**UON Honeysuckle Campus Stage 1A (SSD-9510)
Response to Submissions**

I am writing to you regarding the Stage 1A application for the University's School of Creative Industries and Innovation Hub. As advised in the Department's letter of 23 September 2019 all submissions received by the Department during the exhibition of the proposal are available on the Department's website at <https://www.planningportal.nsw.gov.au/major-projects/project/10196>.

SITE : 16B HONEYSUCKLE DRIVE
NEWCASTLE, NSW, 2300
DRAWING : EAST ELEVATION

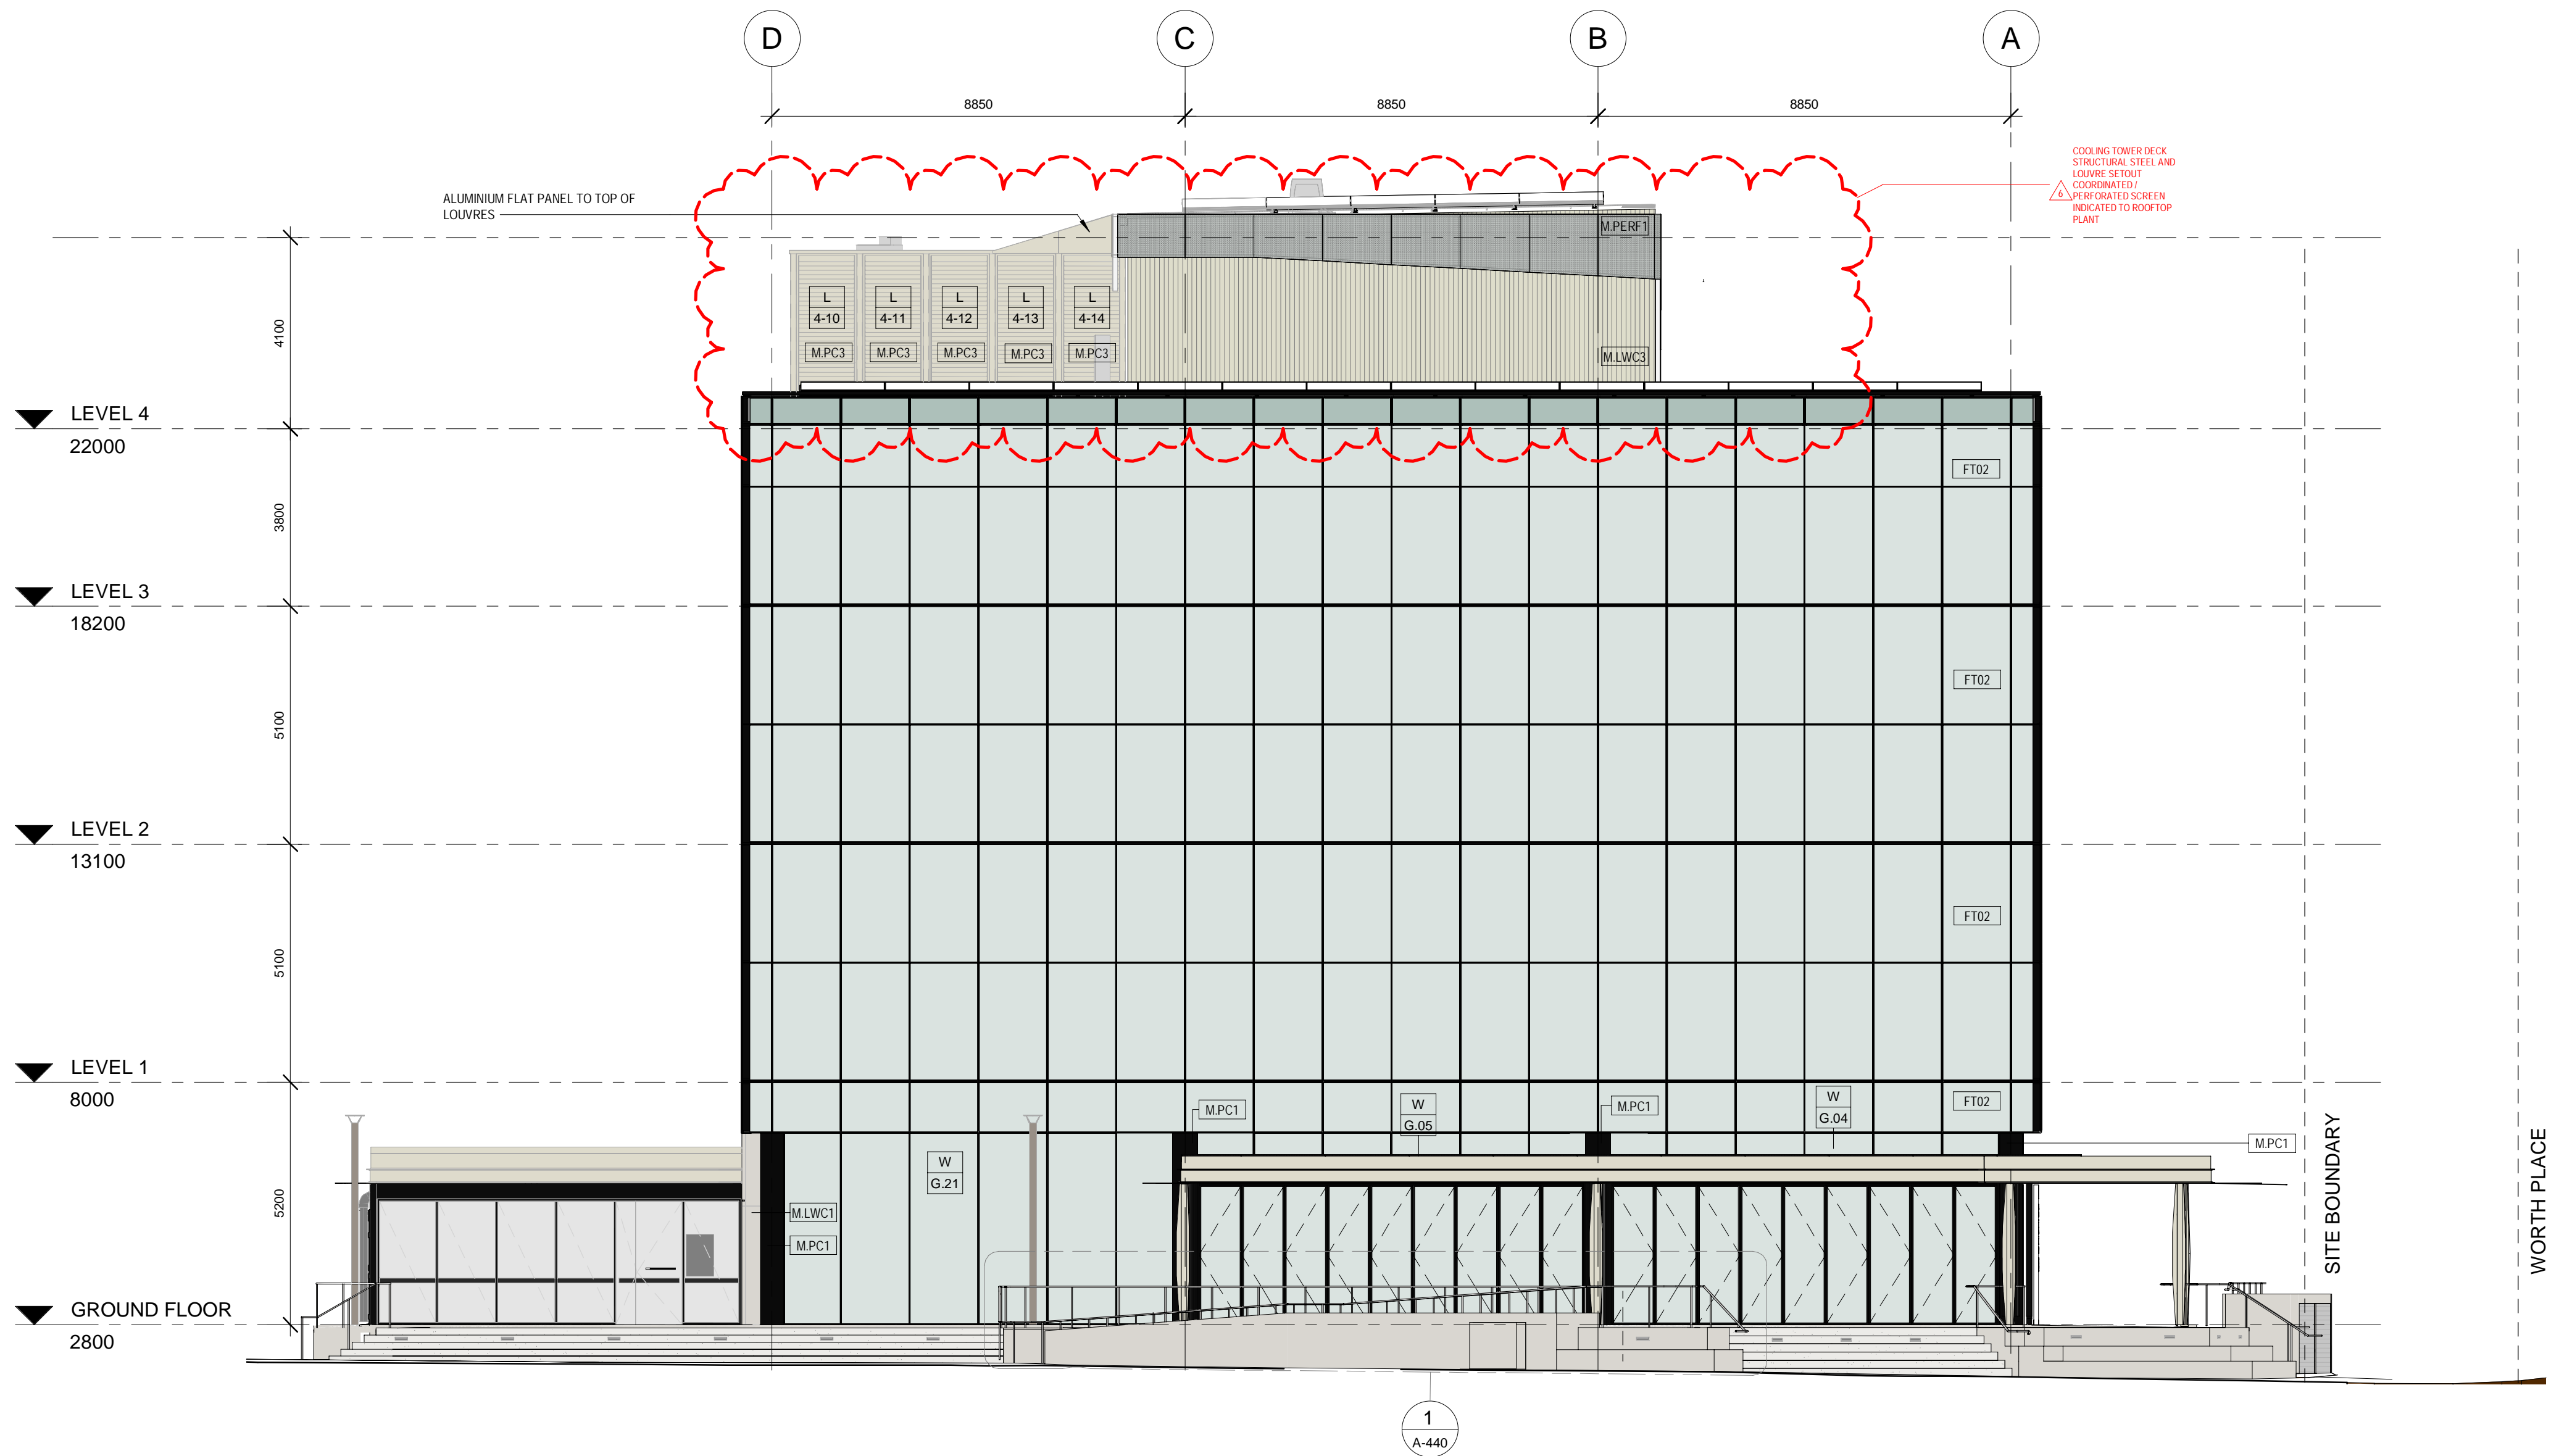
- d) improved integration with the architectural design of the building
 - e) the stairs turn their back on, and present a blank (eastern) wall to, the south-eastern open space.

SITE: 16B HONEYSUCKLE DRIVE
NEWCASTLE, NSW, 2300
DRAWING: PLANT LEVEL PLAN

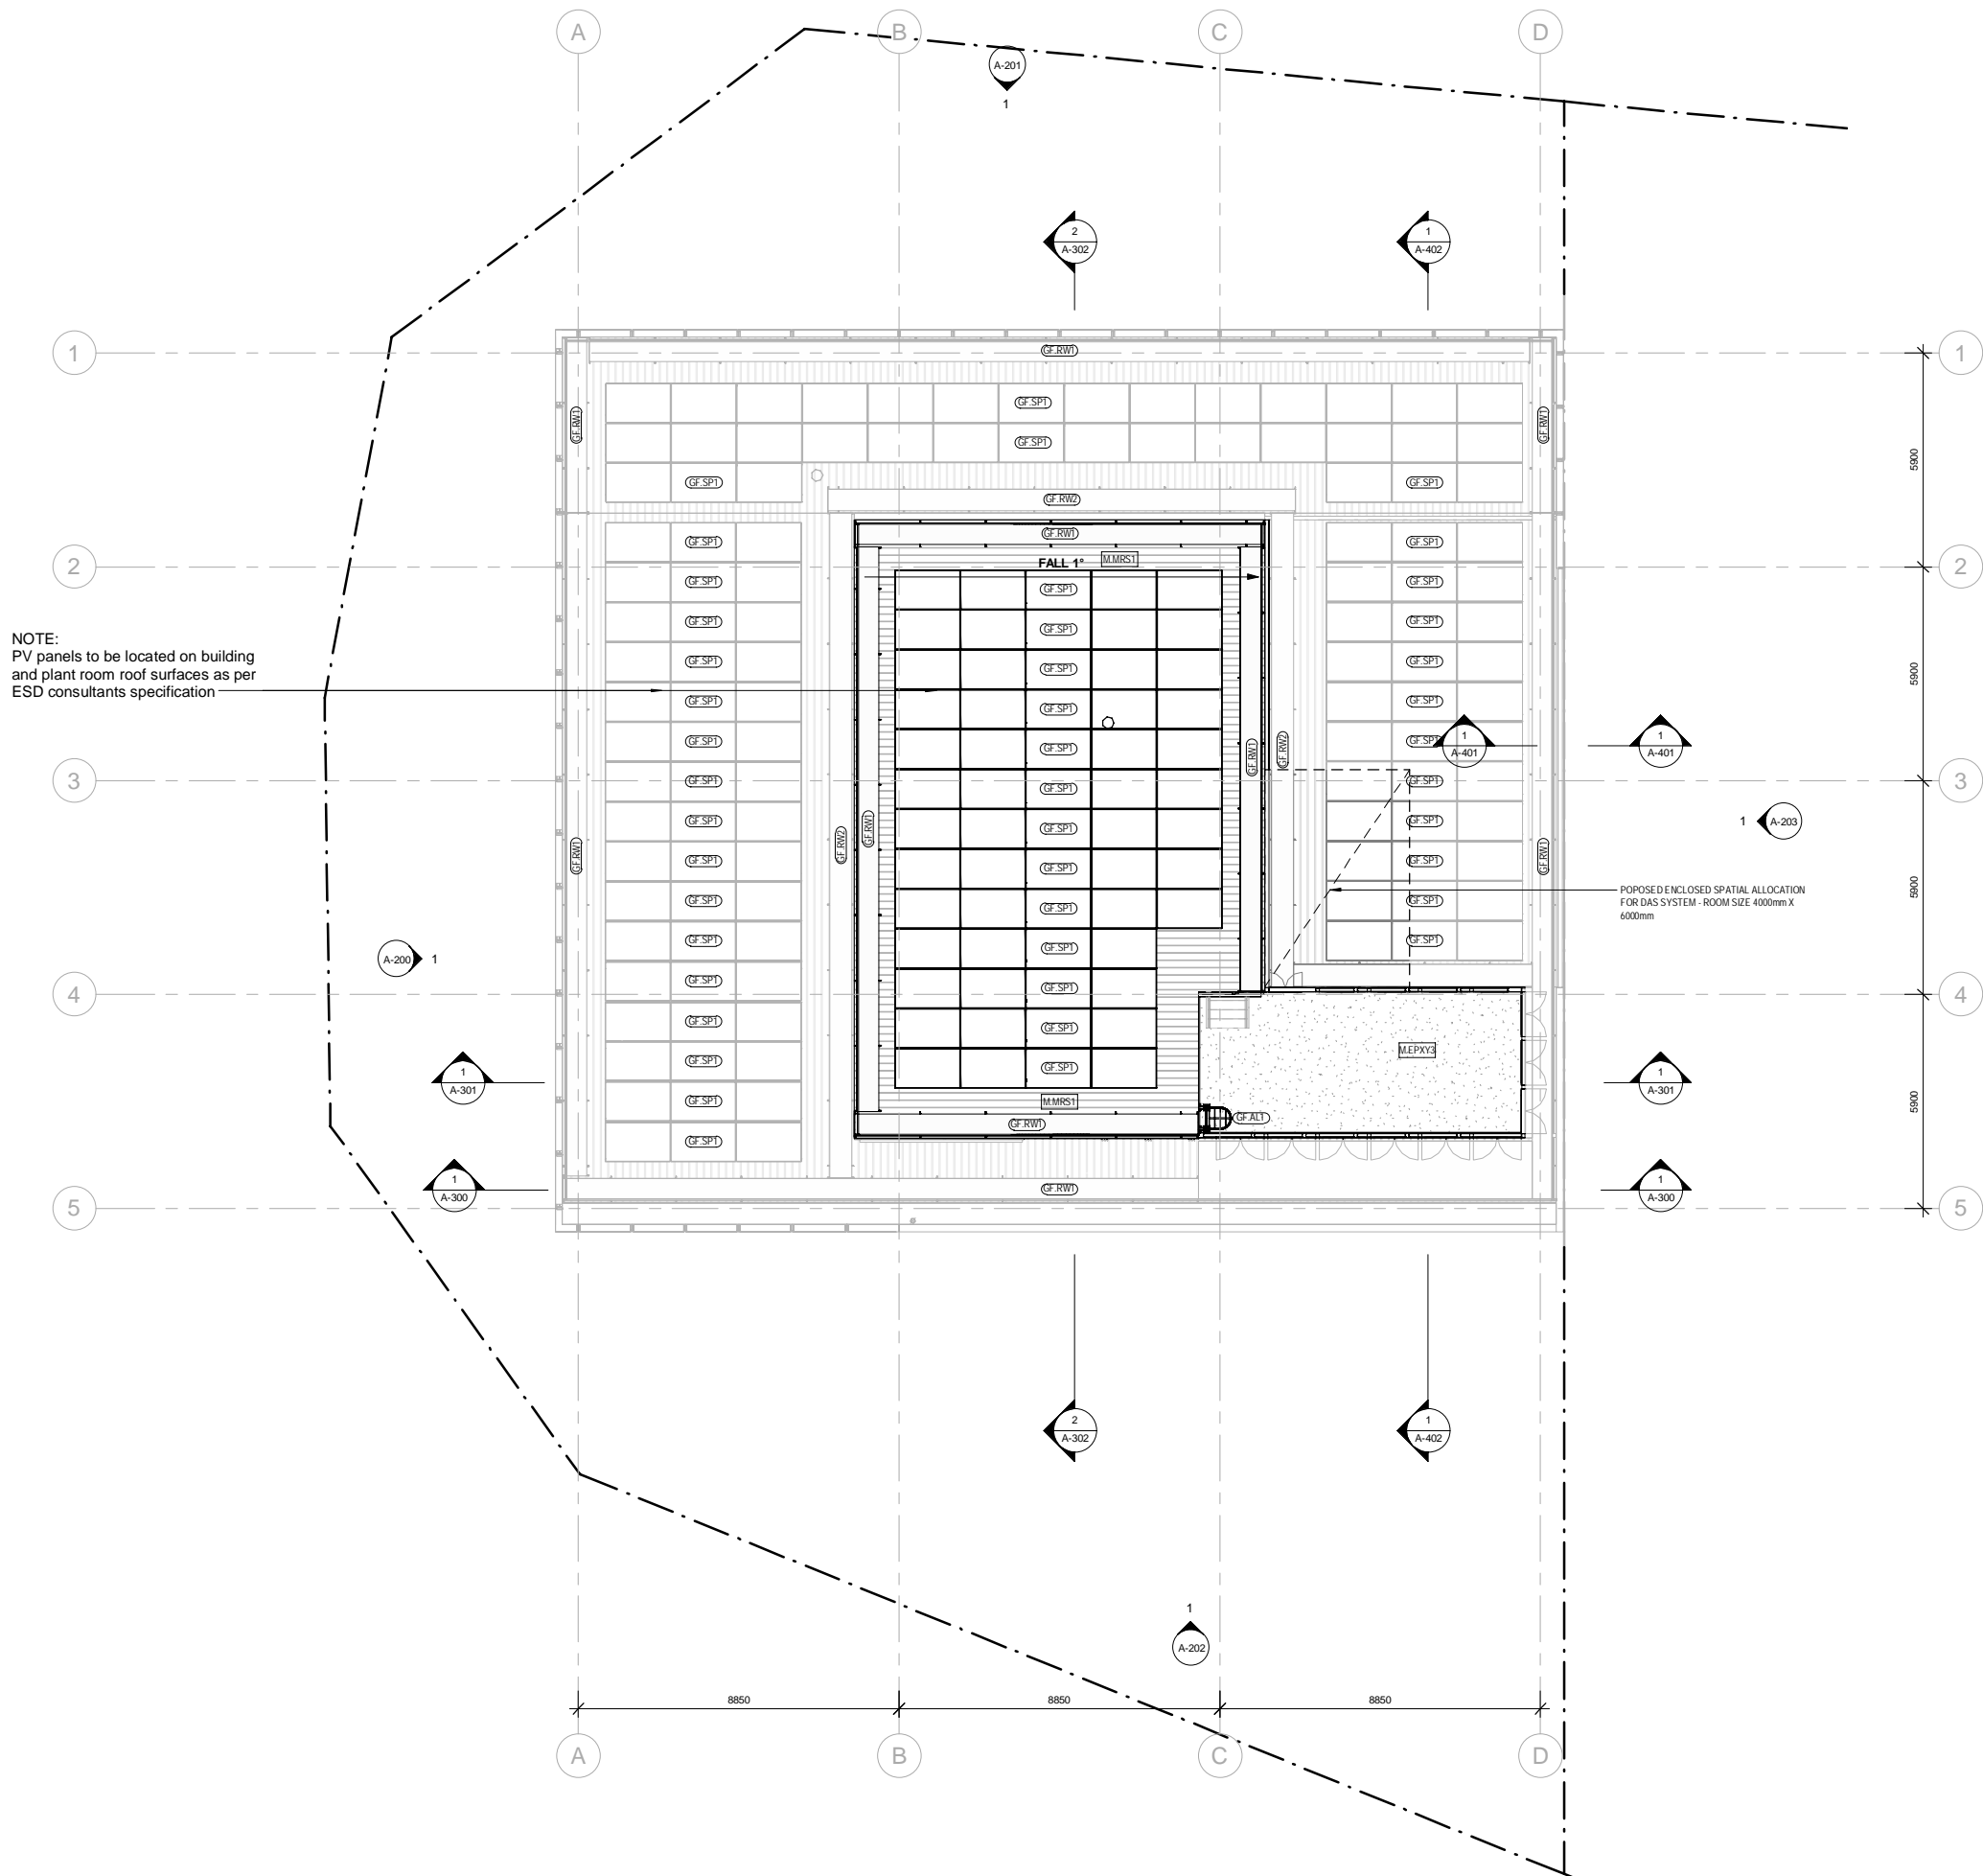
2. The Department notes that the rooftop plant enclosure would be a highly visible feature of the building. Provide justification for its size, height, design and use of handrails and consider options to reduce its visual impact.
